RE: 4950 Jefferson St. NE
Grading and Drainage Plan
Engineer's Stamp Date: 09/25/23
Hydrology File: F17D026A

RE: 4950 Jefferson St. NE
Grading and Drainage Plan
Engineer's Stamp Date: 09/05/23
Hydrology File: F17D026A

Based upon the information provided in your submittal received 09/01/2023, the Grading & Drainage Plans **are not** approved for Building Permit and Grading Permit. The following comments need to be addressed for approval of the above referenced project:

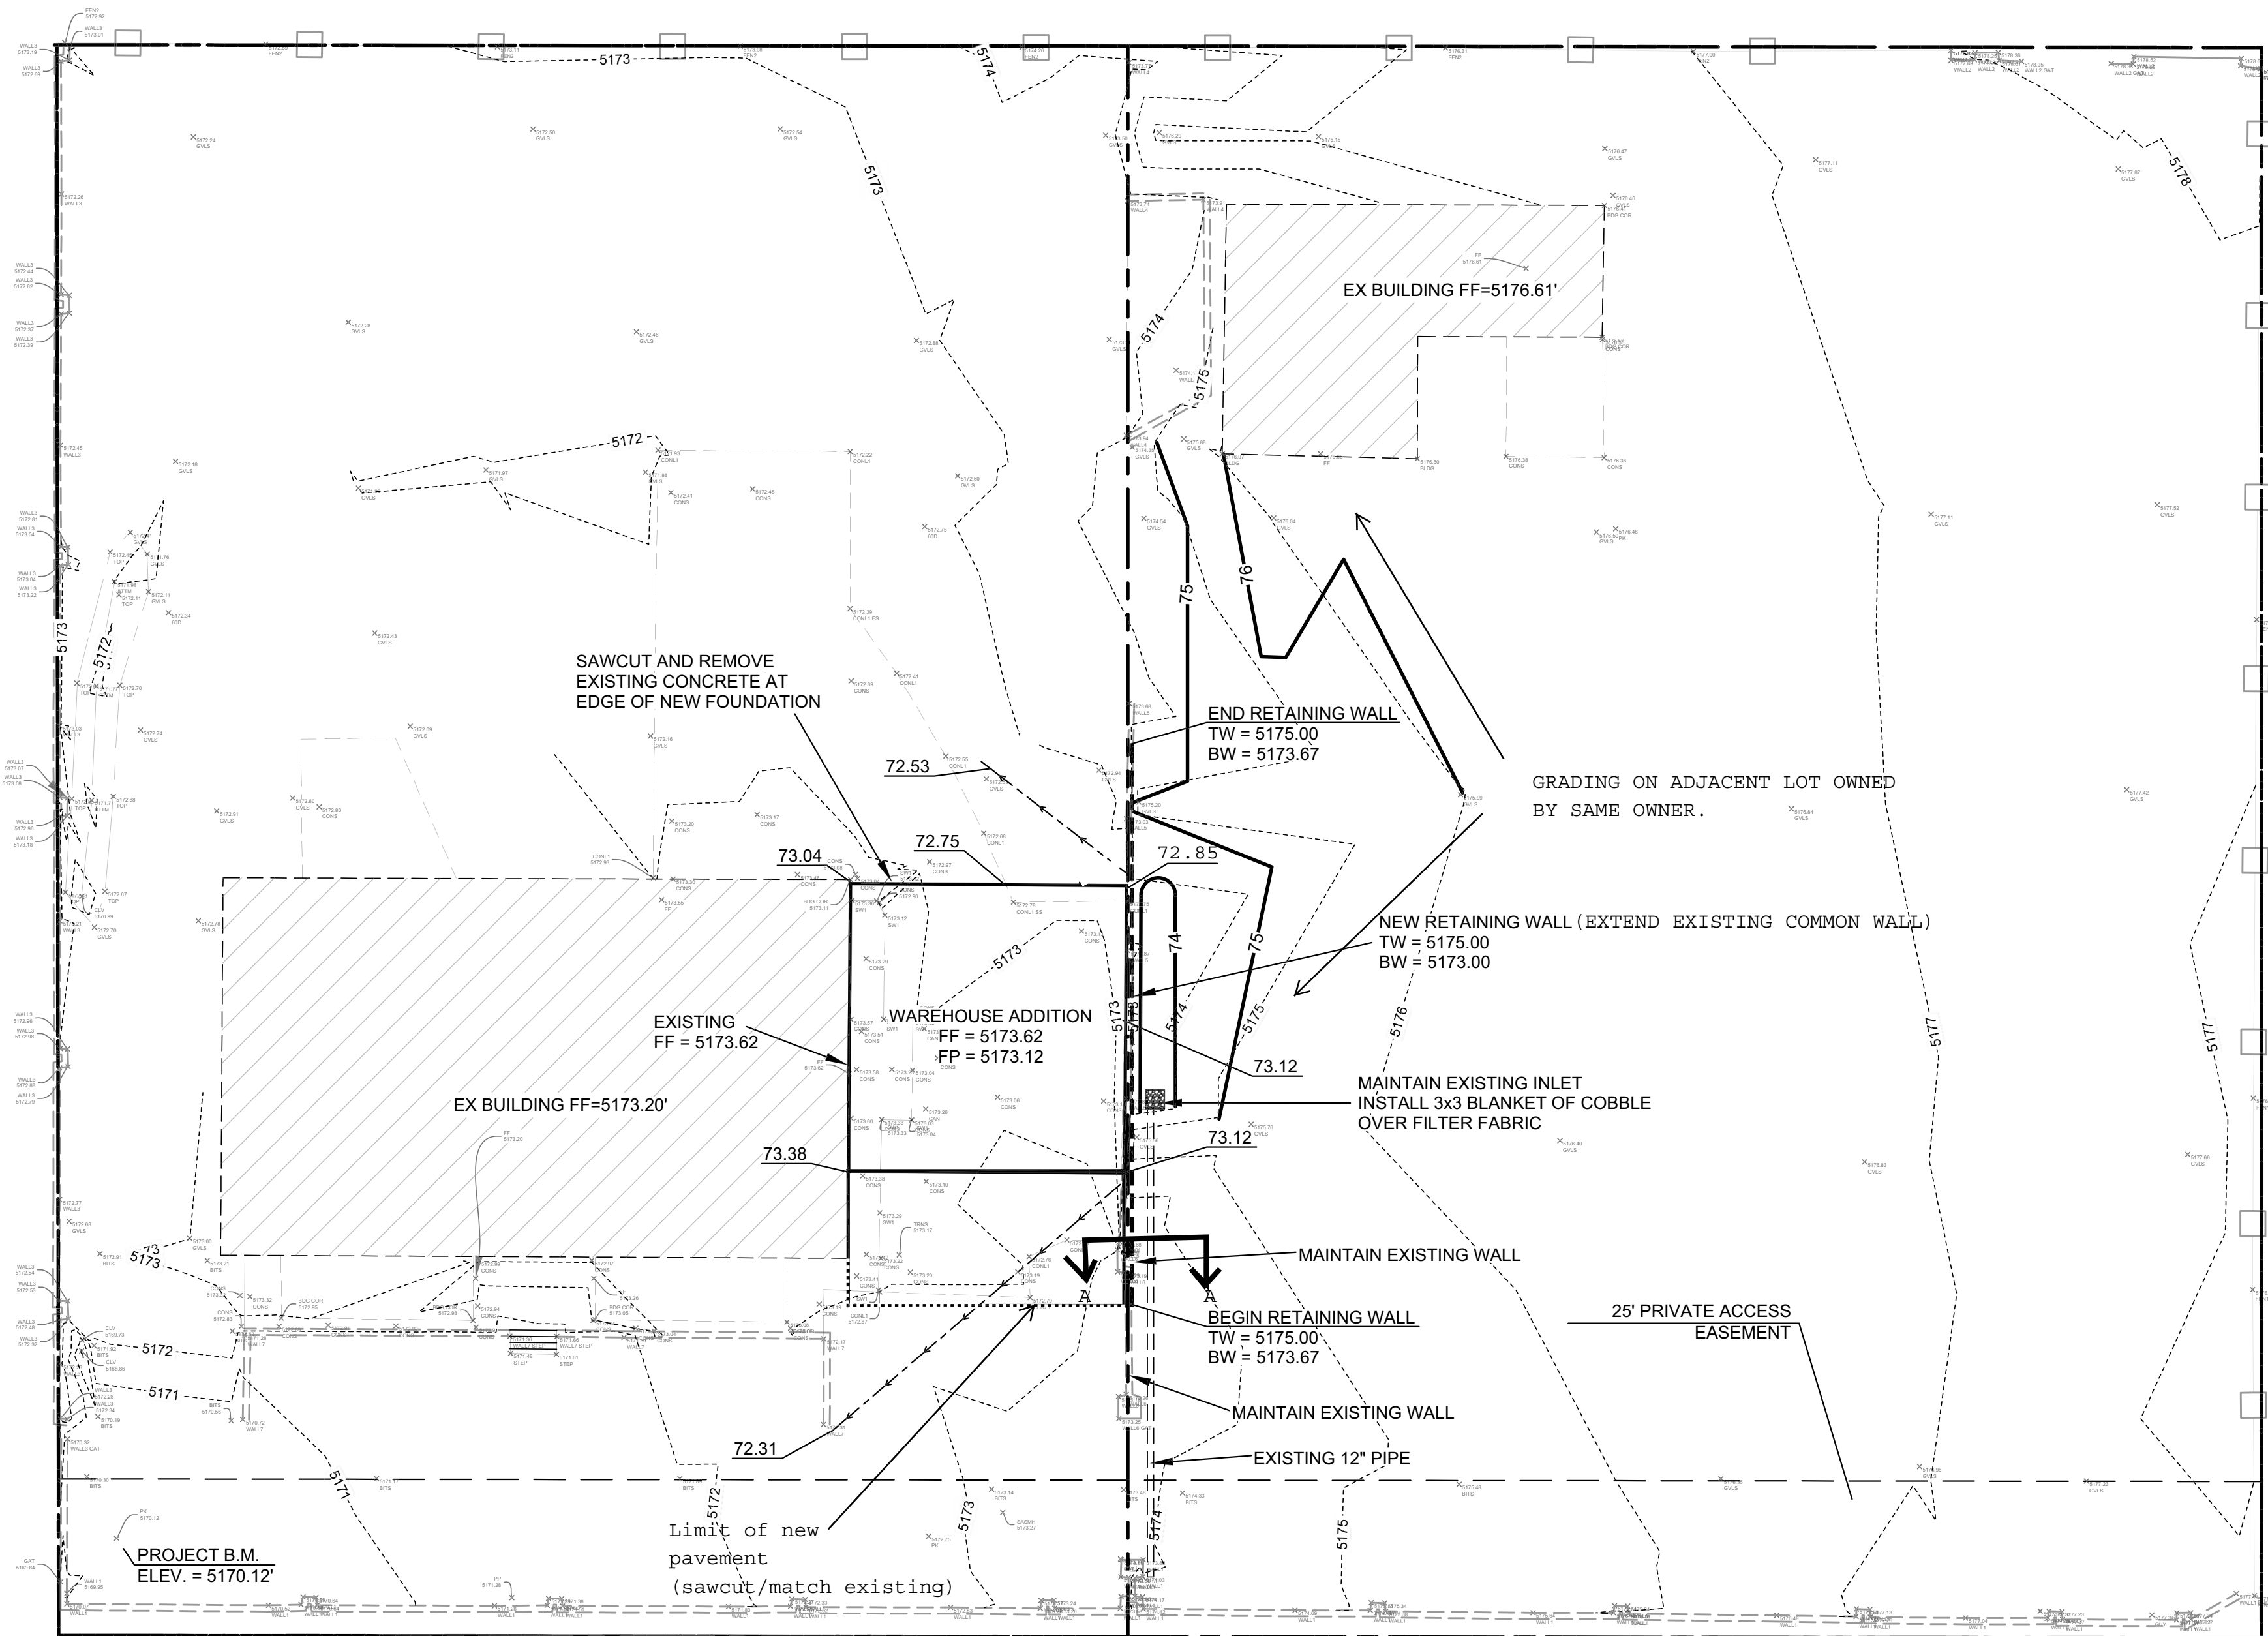
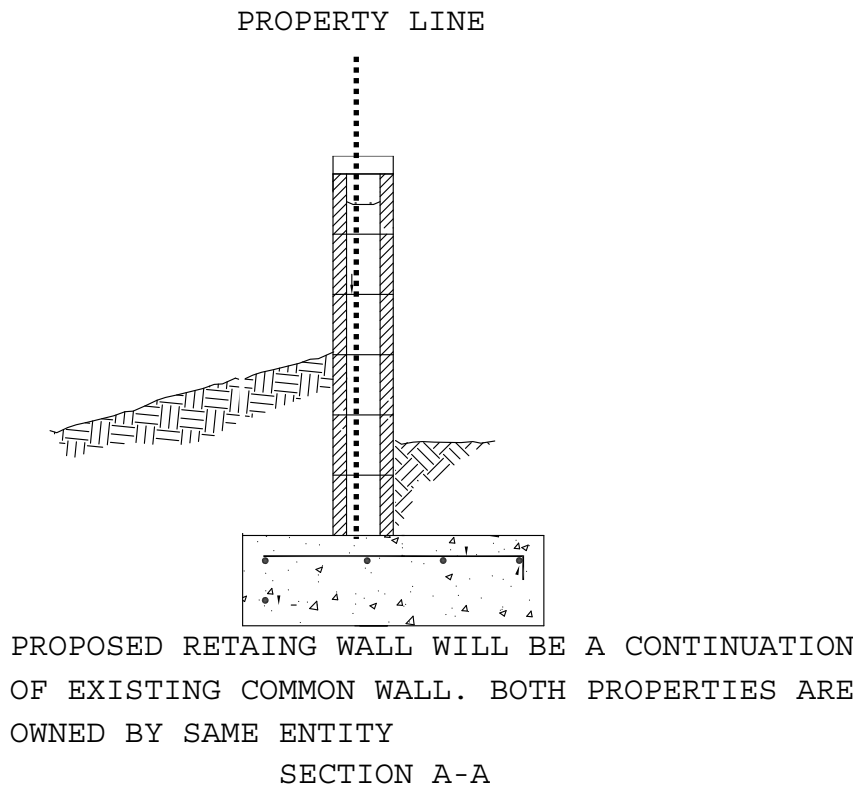
1. Please provide all adjacent property legal description. **ADDED**
2. Please show and label Monroe St. NE. **ADDED**

3. Please show the access easement on the adjacent property and label "Exist. Access Easement (To Jefferson St. NE)". **ADDED**

4. Please provide written. Signed, and notarized permission from the adjoining property owner (Same Owner) for work on that property. **PROVIDED DRAFT, ORIGINAL WILL BE SENT**
5. Please add some more detail to the section between the two properties as shown. **ADDED**
